HARP application 3/2021/0661/HighwayWorksPlan9

I am writing on behalf of The Clitheroe Angling Association to object to the proposal to widen the road and bridge at Grindleton. I refer in particular to sites RW03 and RW04.

UNITED UTILITIES WATER LIMITED
 HAWESWATER AQUEDUCT RESILIENCE PROGRAMME
 RIBBLE VALLEY BOROUGH COUNCIL (MARL HILL)
 HIGHWAYS WORKS PROPOSALS - TYPICAL ROAD WIDENING
 CROSS SECTIONS - SHEET 12 of 12

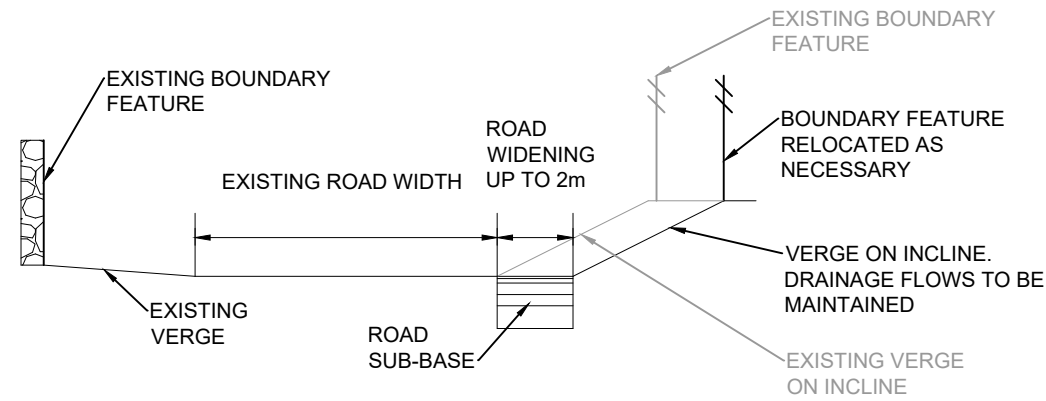
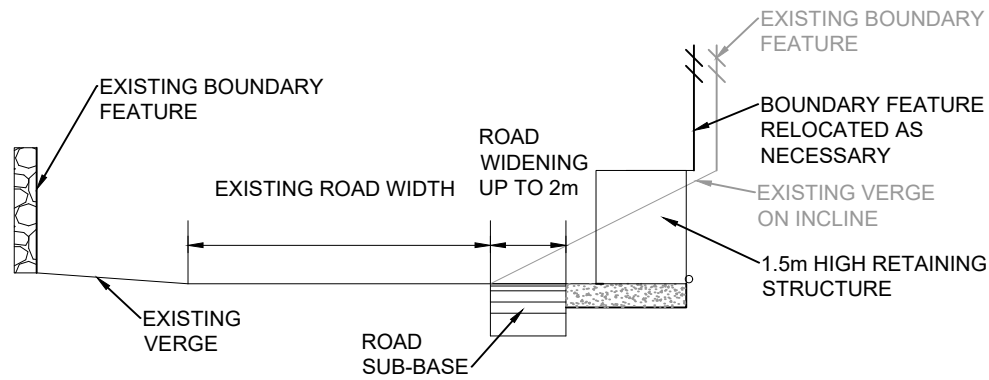
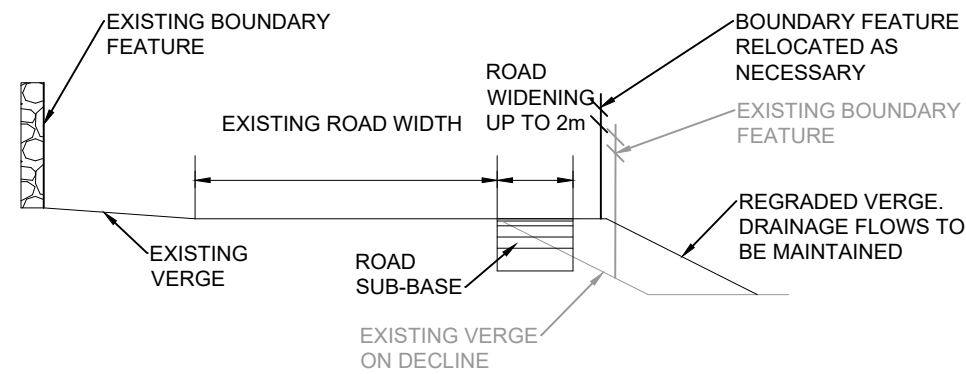
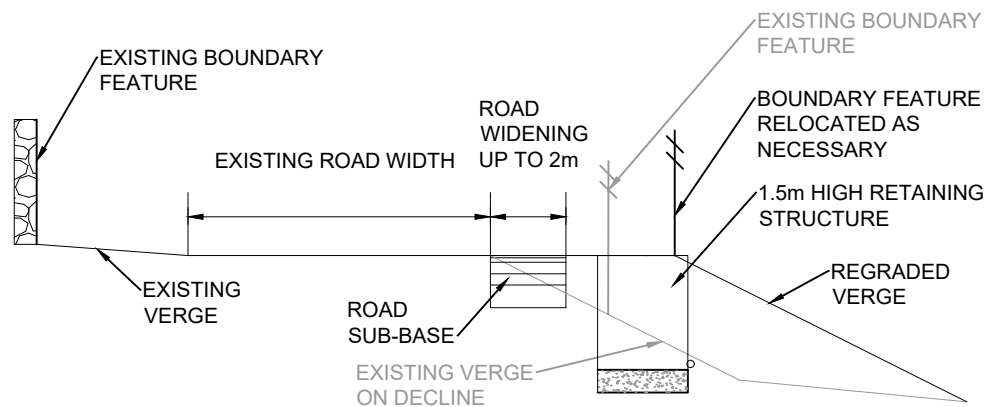
- The site is used by a number of protected species.
 - (i) It is a roosting place for barn owls – these can often be seen at dusk as they leave the roost to hunt.
 - (ii) Swallows and House Martins nest under the bridge every summer. Their nesting sites are protected by law.
 - (iii) Black headed gulls, grey wagtails and kingfishers are frequently seen at the site, as it provides shelter and good feeding territory. All three of these species are considered to be at risk.
 - (iv) Less frequently the following protected species visit the site: greylag goose, curlew, dunnock, spotted flycatcher and reed bunting.
 - (v) A variety of species of bat roost under the bridge.
 - (vi) Otters pass through most nights as they hunt.

- The works adjacent to the river will inevitably lead to a considerable amount of pollution through silt. This is unlikely to directly result in fish kills. However, it has catastrophic consequences for the invertebrates at the bottom of the food chain; therefore there will a significant negative impact on fish and bird life.

- Parking heavy machinery adjacent to the river is likely to result in diesel / petrol leaking into the water system – the consequences of this could be catastrophic for wildlife. It is vital to ensure that such leakages cannot affect the water course.

A cursory inspection of the site will reveal that significant repairs have already been carried out both upstream and downstream of Grindleton Bridge. The effects of the proposed works would be to increase flood risk and cause further damage to the river bank in times of high water due to the increased turbulence.

- Many of our members are elderly. Some are therefore restricted to fishing within a couple of hundred metres of the bridge and rely on being able to park in close proximity to the bridge in order to enjoy their recreation. There would appear to be nowhere for the general public to park under the new proposals.
- As mentioned earlier, pollution from silt is inevitable and such pollution often renders the river unfishable.
